Our ref: DOC20/411214

**Notice of Exhibition of Pitt Street South Over Station Development Stage 2 (SSD 10376)  
- Comments on Environmental Impact Statement**

Thank you for your referral inviting the Heritage Council of NSW to provide comment and recommended conditions of approval for SSD 10376 - Pitt Street South Over Station Development Stage 2 (the proposal).

Figure 2.7
 Perspective render of the proposed Pitt Street lower facade
 Source: Bates Smart Architects

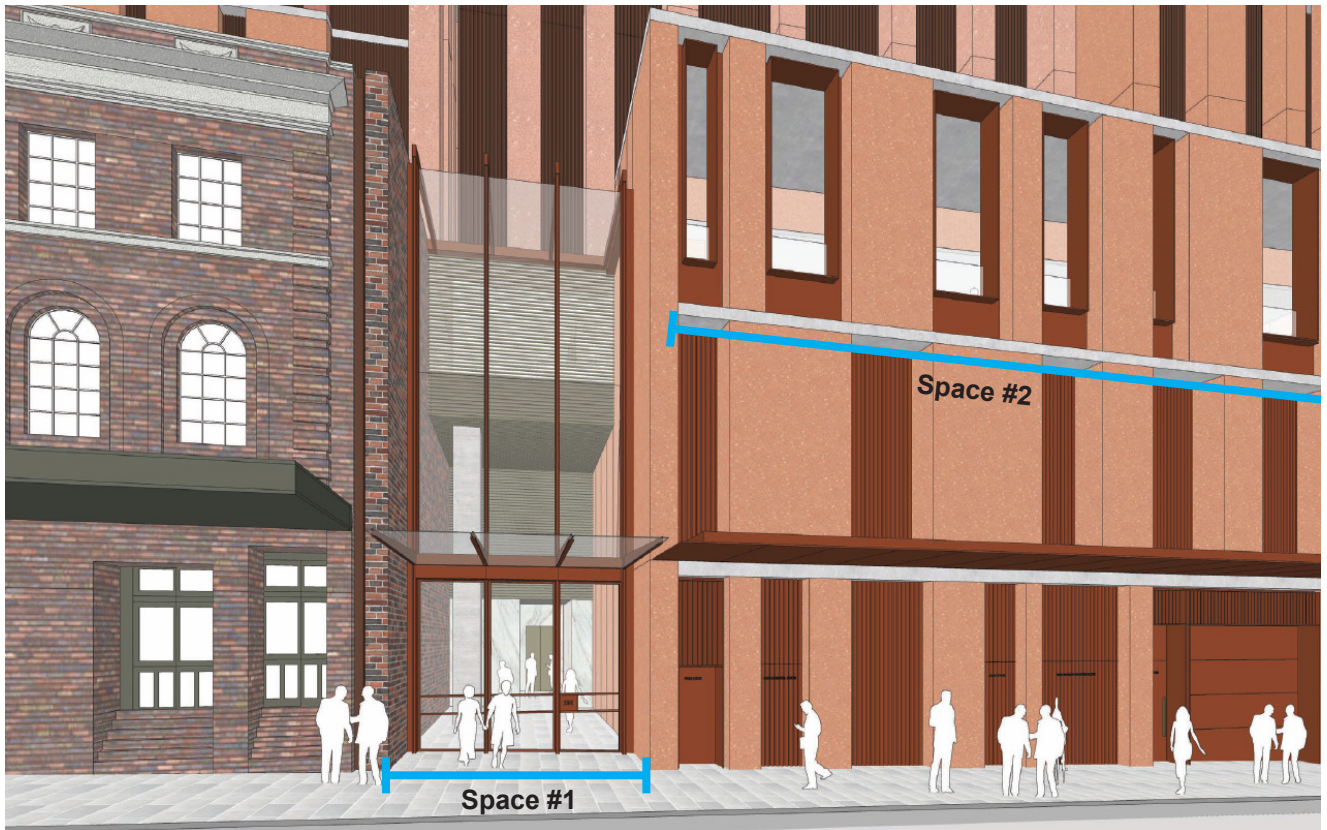
We acknowledge the well-considered podium façade design to respond to the scale and character of the surrounding context. However, the EIS provided only limited information on how the western façade of the Pitt Street podium responds to the Institutional Inter-War Functionalist façade of the Sydney Water Board Building opposite, and to the civic character and rhythm of both sides of Pitt Street.

- b) **Heritage NSW and/or Heritage Council (or its Delegate) be consulted:**
  - i. at key stages of the detailed design development of the **Pitt Street podium**; and
